From: Laura Gibbons <Laura.Gibbons@arun.gov.uk>
Sent: 22 June 2021 14:23
To: Planning.Responses <Planning.Responses@arun.gov.uk>
Cc: Raymond Cole <Raymond.Cole@arun.gov.uk>
Subject: RE: Planning Consultation on: P/132/20/RES

Application No: P/132/20/RES

Site Address: Land north of Hook Lane Pagham

Description of Works: Approval of reserved matters following P/30/19/OUT for 300 No. new homes, internal roads, footpaths & cycleways, car parking & landscaping. This application affects the setting of a listed building & falls within Strategic Site H SP2, CIL Zone 1 (Zero Rated).

Project	Hook Lane, Pagham
Drawing	Site Layout
Client	Hallam Land
Job no.	HALL200505
Dwg no.	SL01
Author	AS
Status	PLANNING
Client ref.	
Date	June 2020
Revision	A
Scale	1:1000 at A1
Office	Romsey

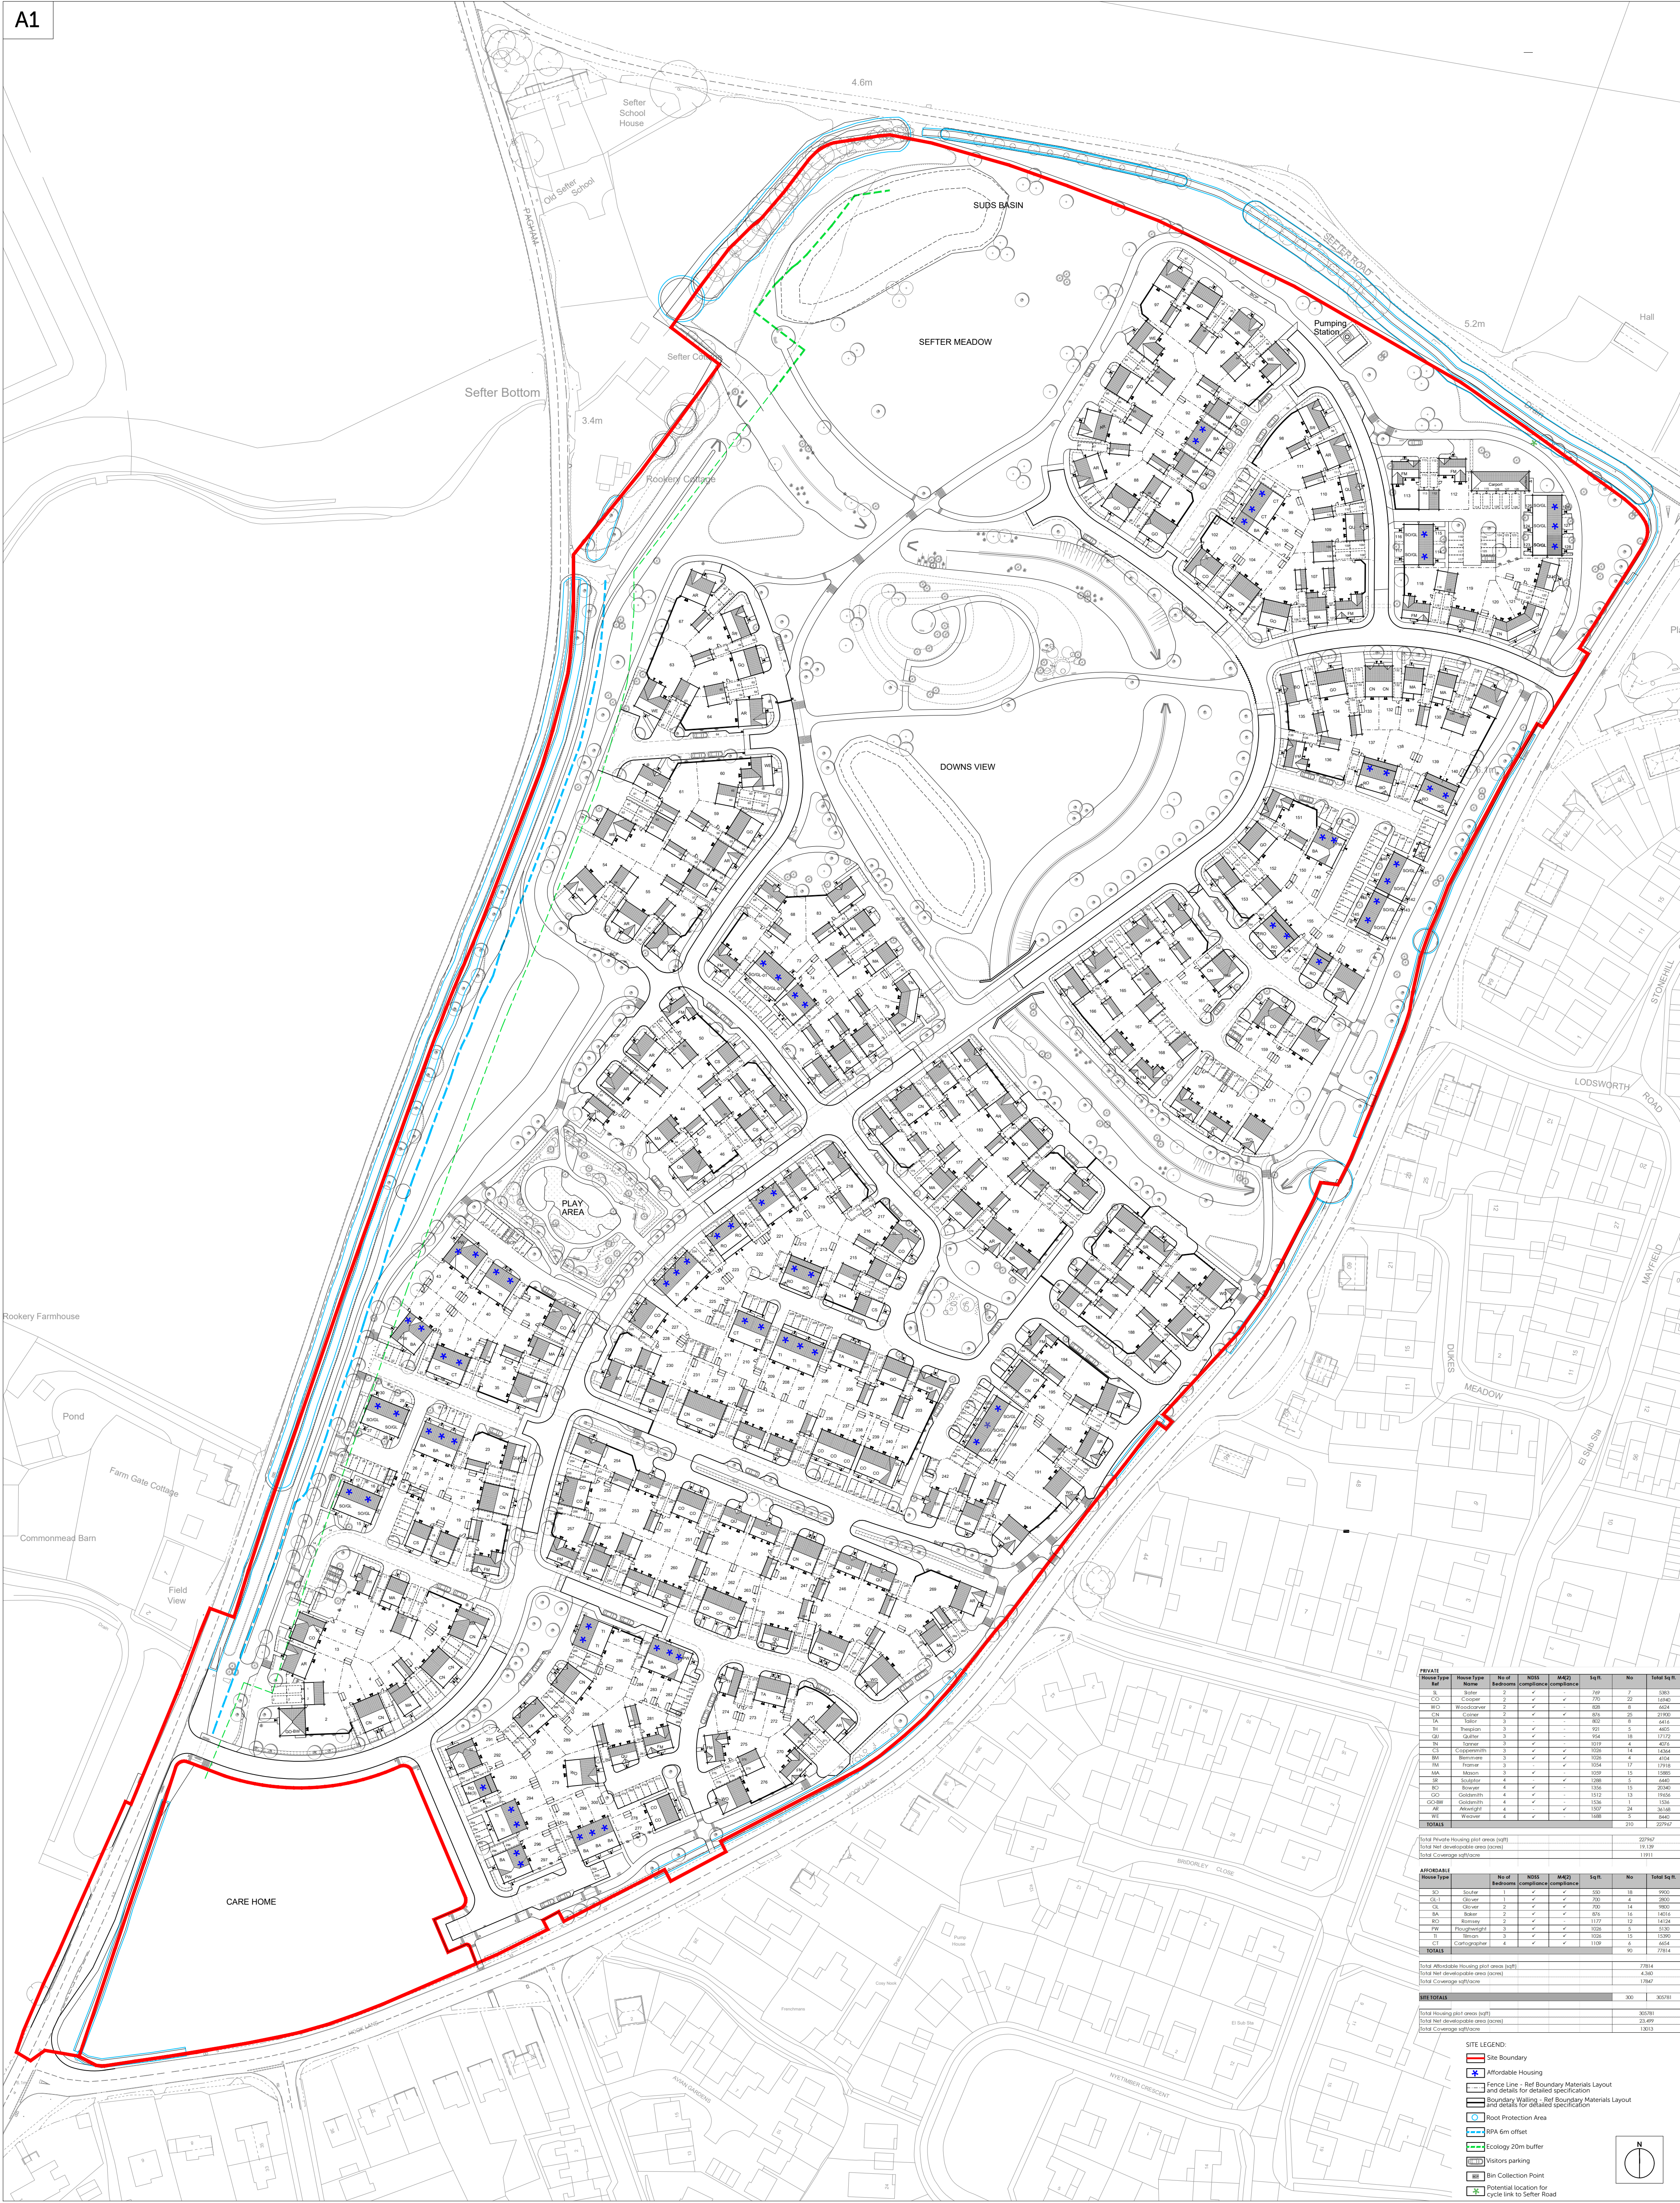
The proposed layout relies heavily upon realigning an ordinary watercourse. We have not been provided with adequate levels information of the upstream and downstream watercourses to be able to determine if the proposals are achievable. (This was referred to in points 3 and 5 of our previous response).

The surface water drainage strategy still proposes to discharge all water to one location. Natural catchments must be followed, and a second location for discharge should be provided. (This was referred to in point 7 of our previous response).
